### **Sydney West Metro – State Significant Infrastructure SSI-10038**

The National Trust of Australia (NSW) lodges a submission on the potential heritage impacts on the Parramatta area, associated with the construction of the Sydney West Metro.

Figure 12-2: Parramatta metro station construction site – Heritage items and conservation areas

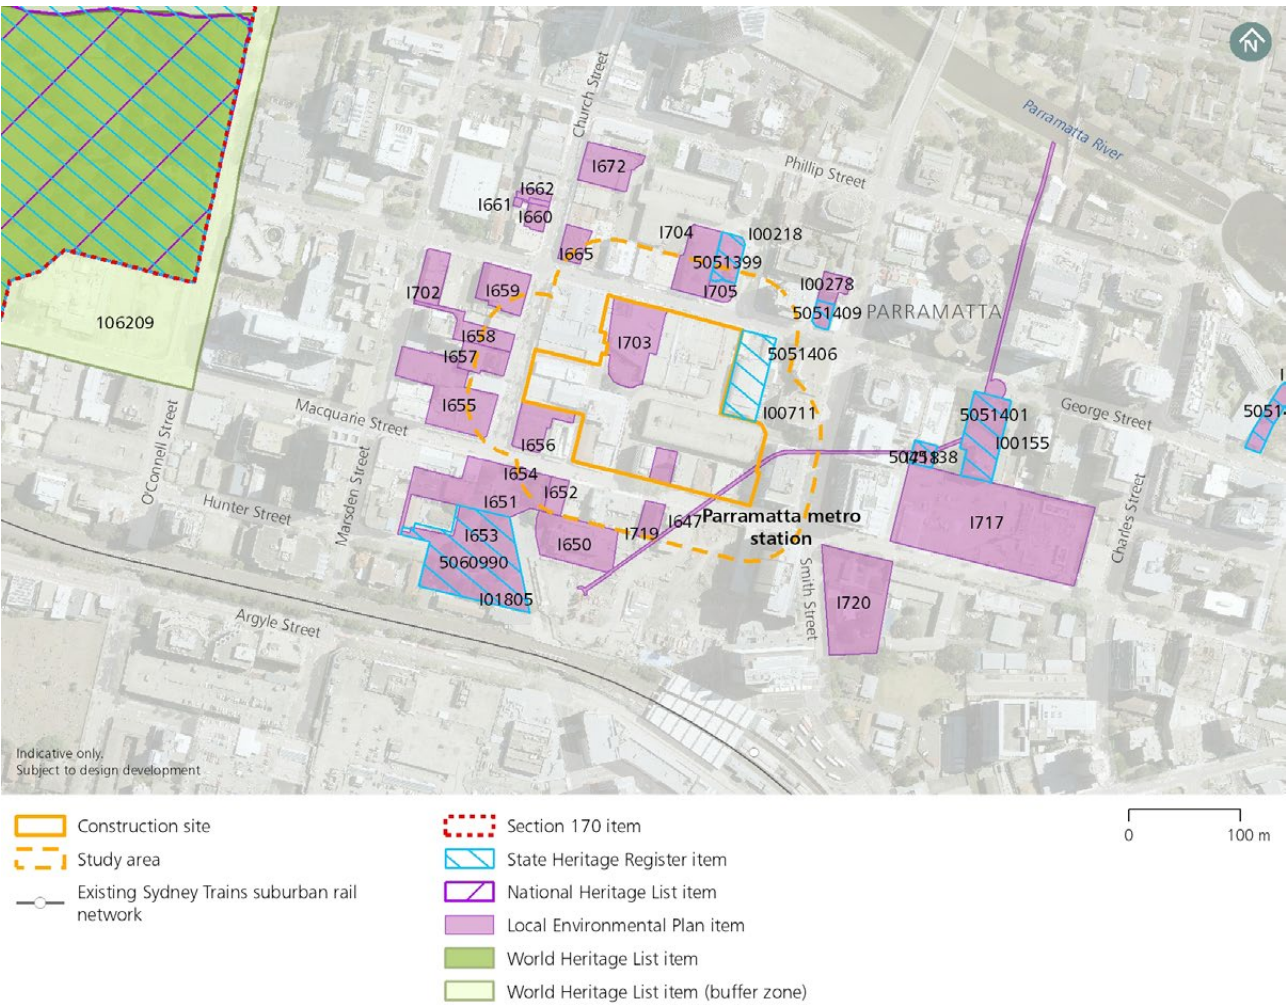
The Trust also has concerns of the heritage impacts of positioning the new Parramatta Metro station in the centre of Parramatta. The location is likely to require full archaeological salvage of any remaining historical archaeological resources in that area, which are assessed as both highly significant and very rare in Parramatta.

While in situ retention of archaeological evidence is proposed, this is highly unlikely to be a feasible option from a construction perspective, even if it is included as a project commitment.
